Application for a non-material amendment following a grant of planning permission.

Number	42
Suffix	
Property name	
Address line 1	Fitzalan Road
Address line 2	
Address line 3	
Town/city	Arundel
Postcode	BN18 9JS
Description of site location must be completed if postcode is not known:	
Easting (x)	501588
Northing (y)	106794
Description

Single Storey Rear Extension	
Reference number:	AB/116/20/HH
Date of decision	16/12/2020

Extending the single storey extension out from the approved footprint by an additional 400mm out from the house into the garden. The extension footprint would not change from the approved plan in respect of the side boundary. The extension would also not extend any further into the garden than the existing adjoining kitchen extension.

Proposed Ground Floor Plan

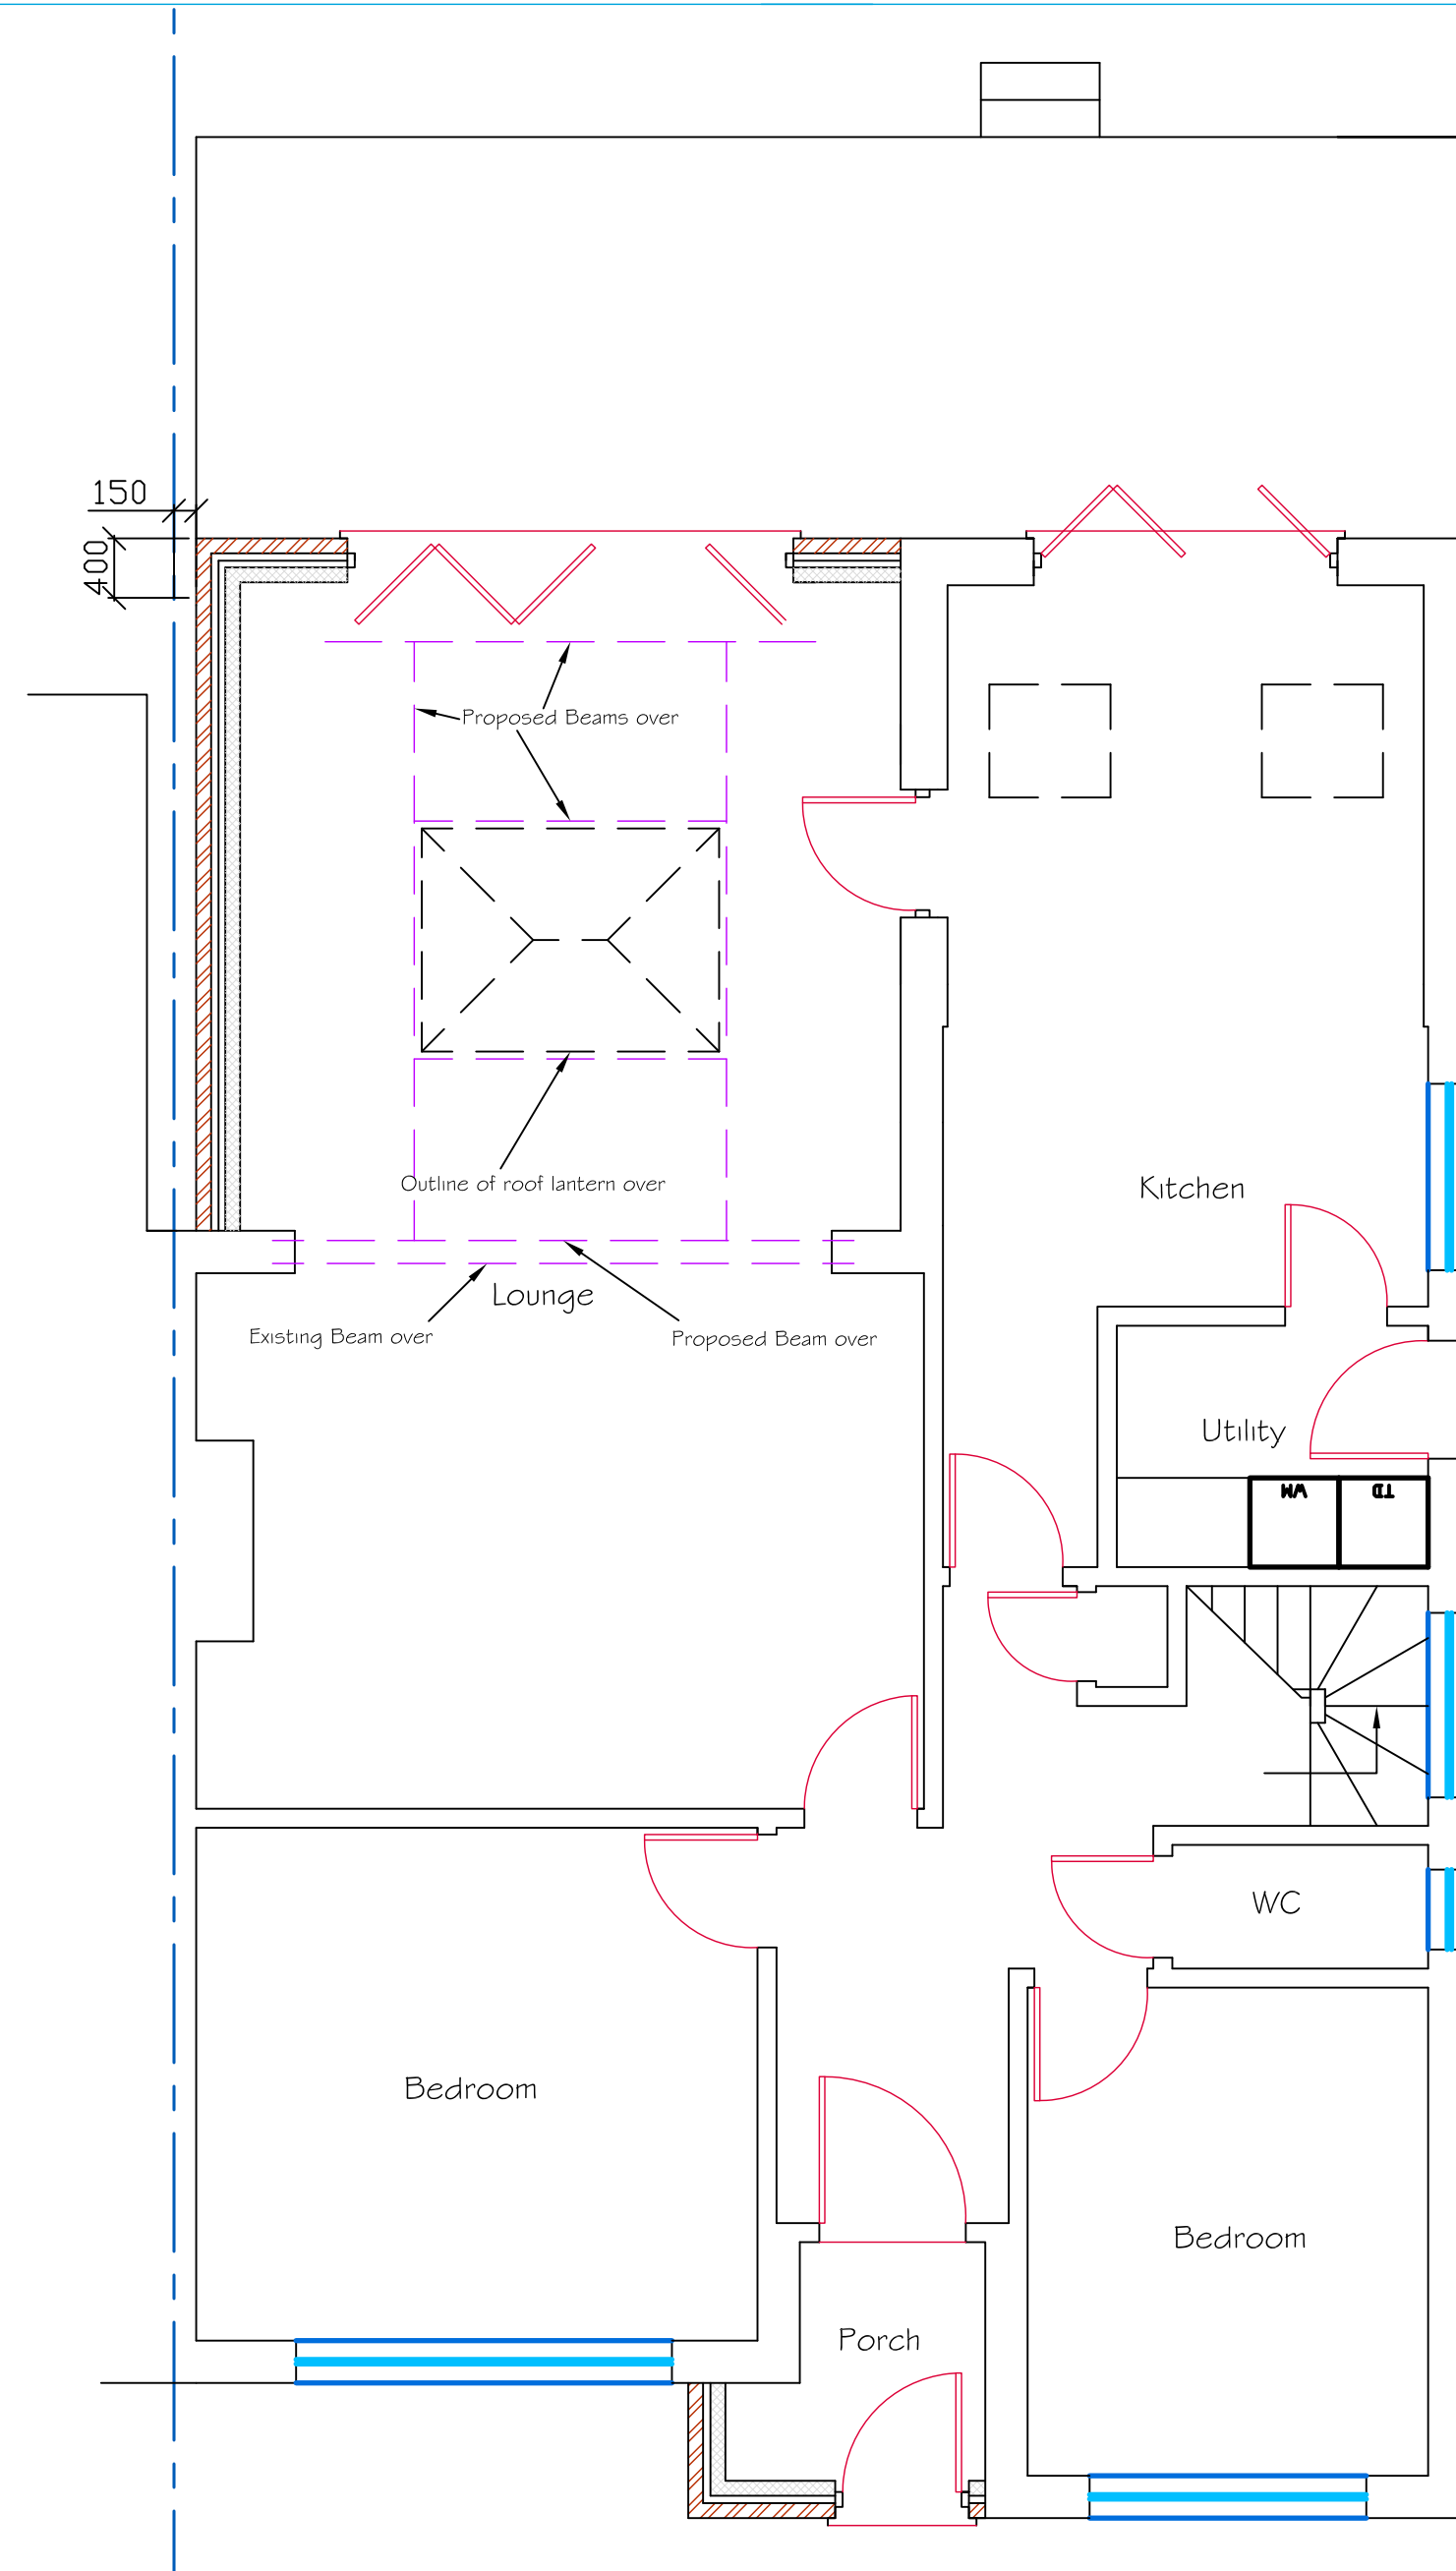
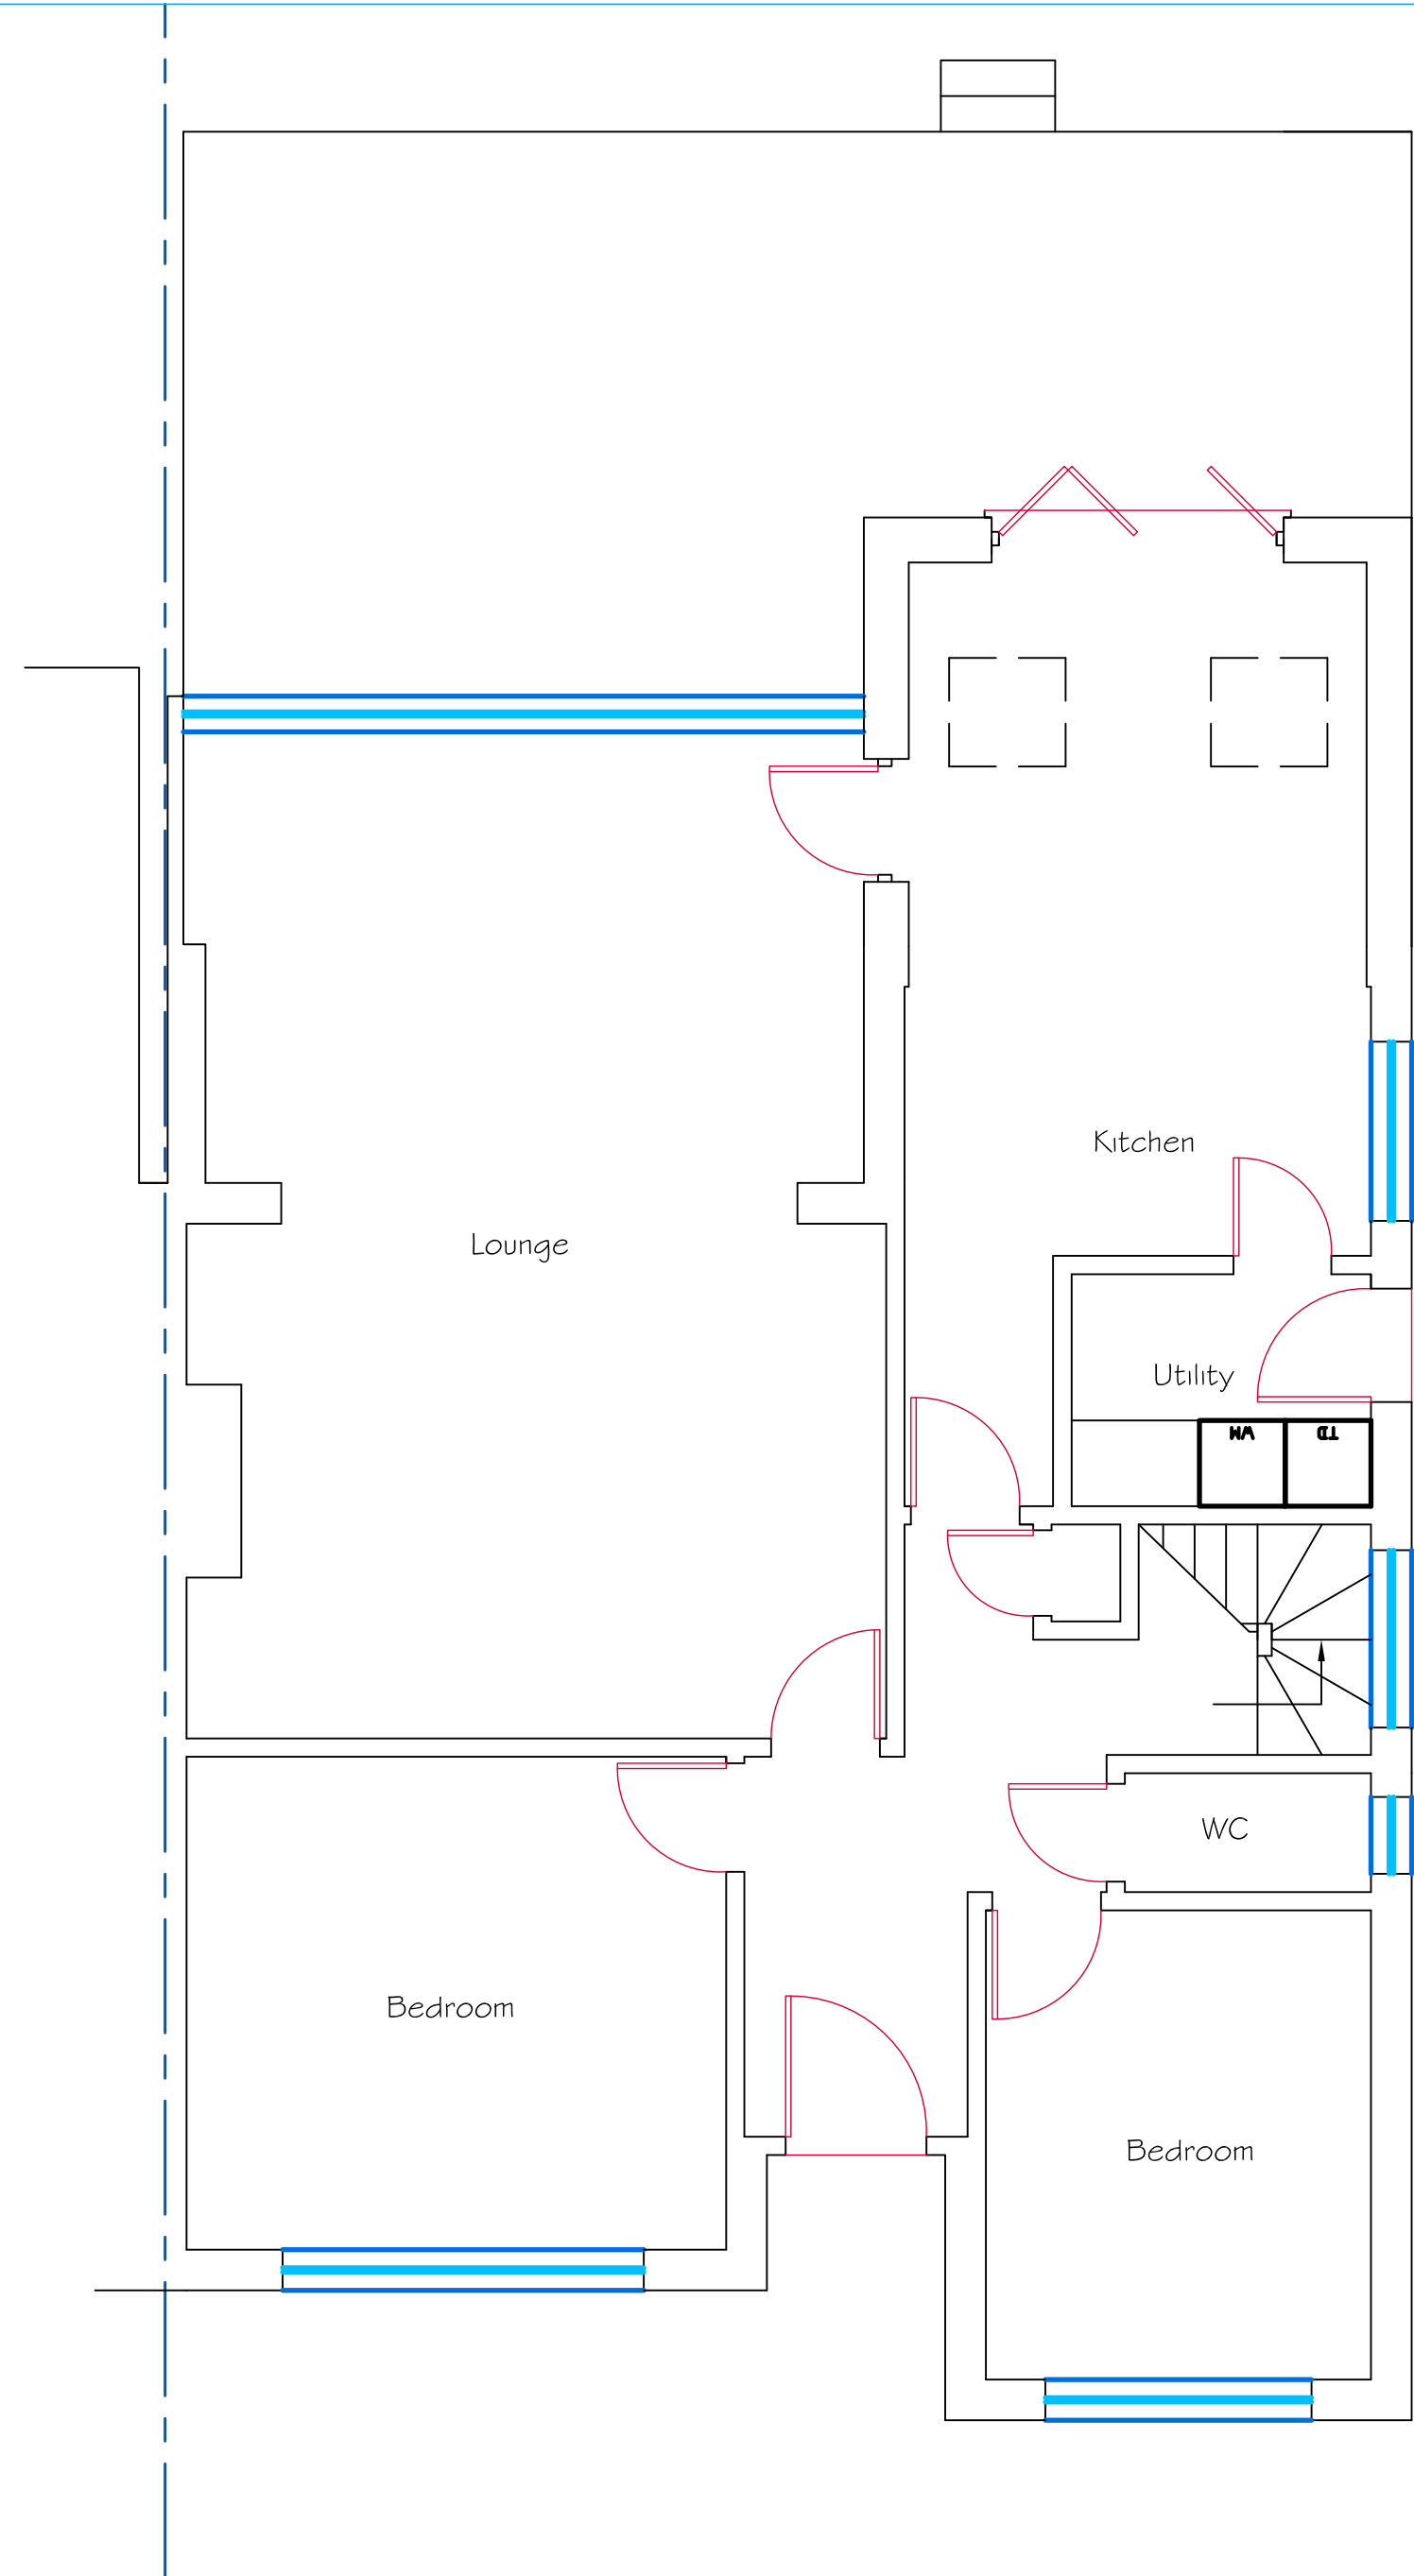
To ensure foundations avoid some underground features and to insure not loss on internal floor space when compared with the original conservatory.
